Open Floor Hearing: 10 March 2026

Dr. Linda Twohey

Title: Figure 3.1.1 Field Numbering Plan
Green Hill A & A.2

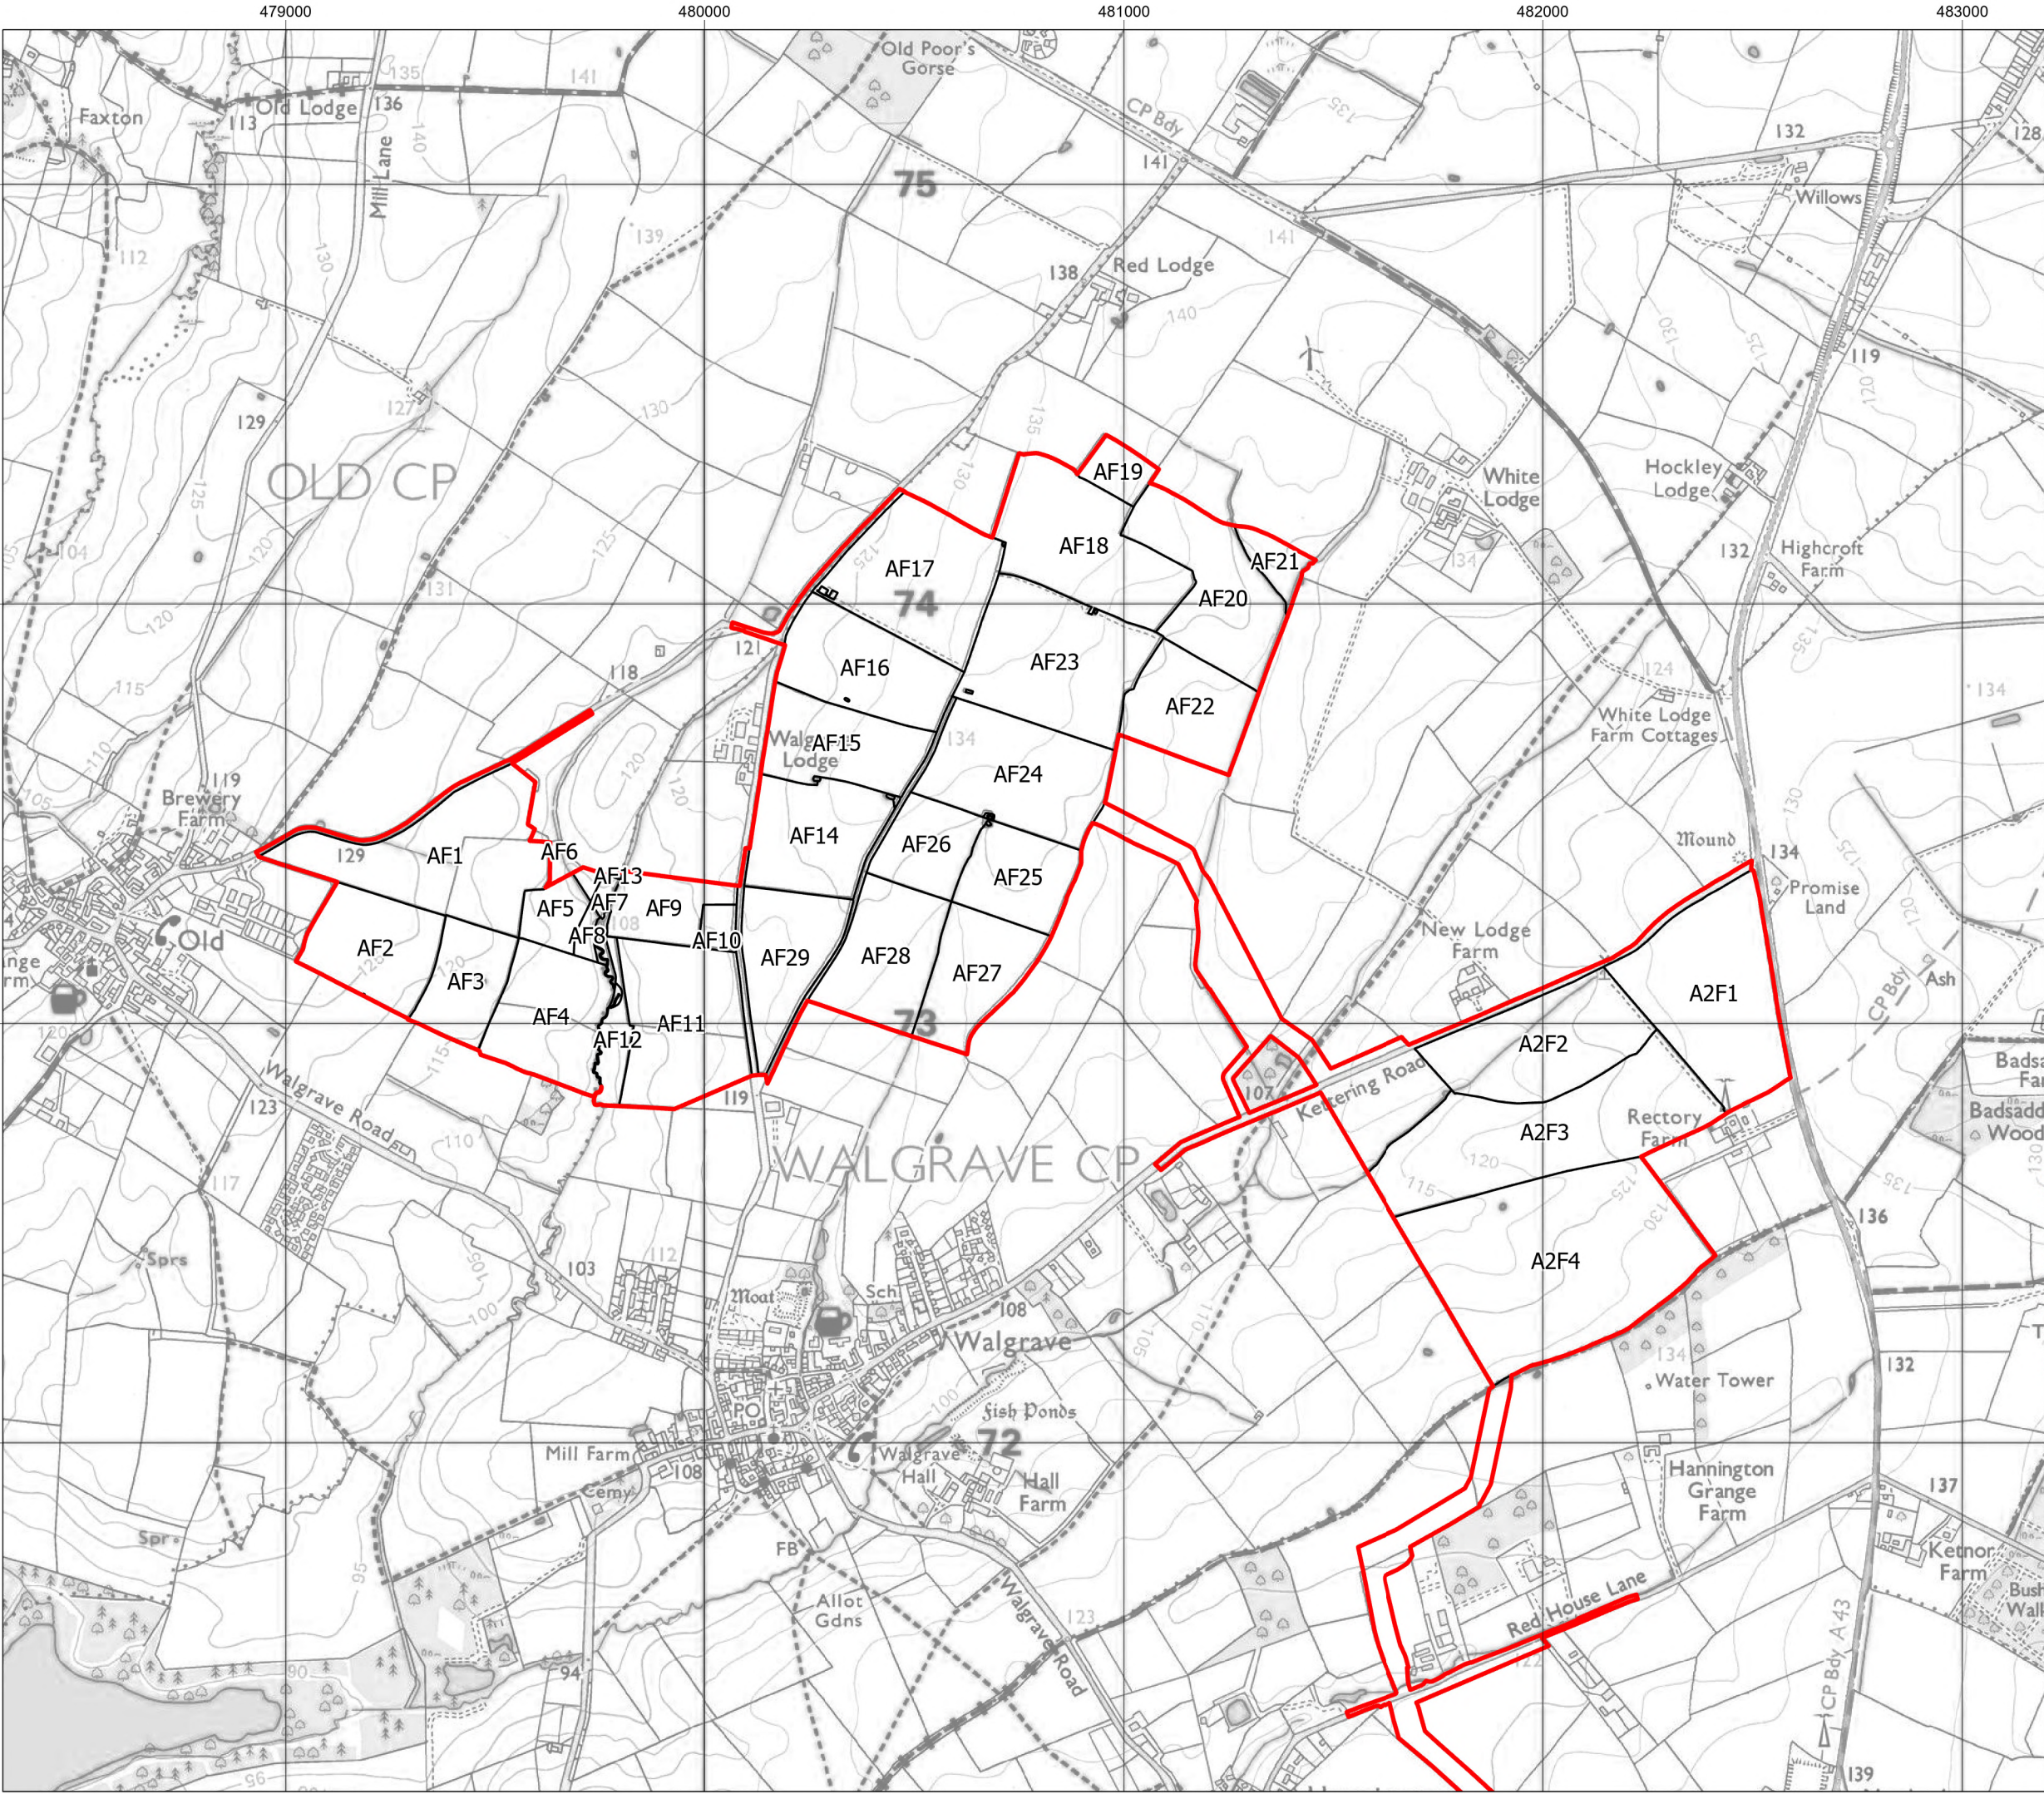
Subsequent to this change, I plan to address why development should now also be removed from field AF9, and the interrelated issue of construction access to fields AF2,3 and 4.

Now that the designated Quiet Lane, Newland Road, will be less directly impacted by the proximity of 4.5 metre solar panels, I wish to question any necessity to place solar arrays in field AF9. By my calculations, the area of panels planned for this small field is only about 2% of the total within Site A. The use of this field is complicated by the fact that there is a utility, presumably a water main, running diagonally underneath it (CR2-008) which needs to remain accessible. It is also next to a watercourse which is otherwise being preserved from disturbance because of good suitability as a probable commuting and foraging route for otters from Pitsford reservoir, and good suitability for water voles, amongst other ecological reasons. (See APP-090, para 1.4.10, and it's Appendices maps 9.7.1 and 9.7.8). Reference again to CR2-008 shows that the other fields bordering this watercourse,

AF5, AF6, AF7 and AF12 have been designated either for enhanced existing vegetation or for damp grassland.

I wish to address the confusion that appears to me to surround the access route for construction of solar arrays within the fields AF2, 3 and 4 on the west side of Site A, as this is integral to my argument in favour of removing AF9 from solar array usage. In the Applicant's original documents submitted for examination, APP-444, Figure 13.13 shows access locations for Sites and Cable route corridors for Site A. This clearly shows Access A-2 which is just northeast of the village of Old, on the Broughton Road. However, in REP3-064, the Outline Construction Traffic Management Plan Revision B, in Table 4.1, this Access A-2 on the Broughton Road is only listed for use during the operational phase, not construction.

On the latest revision of the Site A map, (CR2-008) it is clear that a length of the Broughton Road by Old is within the scheme order limits, but confusingly, the access track marked within fields AF1, 2, 3 and 4 does not appear to connect to the road here. However, it also does not connect eastwards across the watercourse to Newland Road (the Quiet Lane), so my question is, how are construction vehicles expected to access fields AF2, 3 and 4 for the erection of solar arrays and the associated works planned? In my previous OFH submission (REP3-114), I questioned why construction access to the west side of Site A was not designated to be from the Broughton Road by Old, to minimise any need to cross Newland Road. Disappointingly, the Applicant's response to my submission (pages 33-39 of REP3-129) did not answer this point at all.

Therefore I believe it is essential for the Applicant to address this issue before the end of the Examination process, that is, they must state clearly in amended documentation and mapping what route they **do** intend to use to construct solar arrays in fields AF2 – 4.

It follows then, that if access for construction for fields AF2 – 4 **has** to be from Access point A-2, the Broughton Road by Old, (as I believe it has to be), then if the very small area of solar arrays in field AF9 were removed from development within the scheme, there would be no need for Crossing points A-1 east and west on the Newland Road at all. So then no permanent access track would be required through the northern end of field AF29 (which has already been removed from solar array use). This field would then benefit from being able to support arable farming in the entire field. Ecological benefits include no longer needing to remove 2 portions of important hedgerow, one between fields

AF29 and AF14, and the other between AF29 and Newland Road for Access A-1 (E) and skylark territories in that field would not have to be disturbed.

I should therefore, respectfully, request that the Examiners recognise the logic of this argument, with it's very small reduction in energy generation set against enormous benefit to local residents, and consider the removal of field AF9 from development in any eventual DCO, if they are minded to grant one.
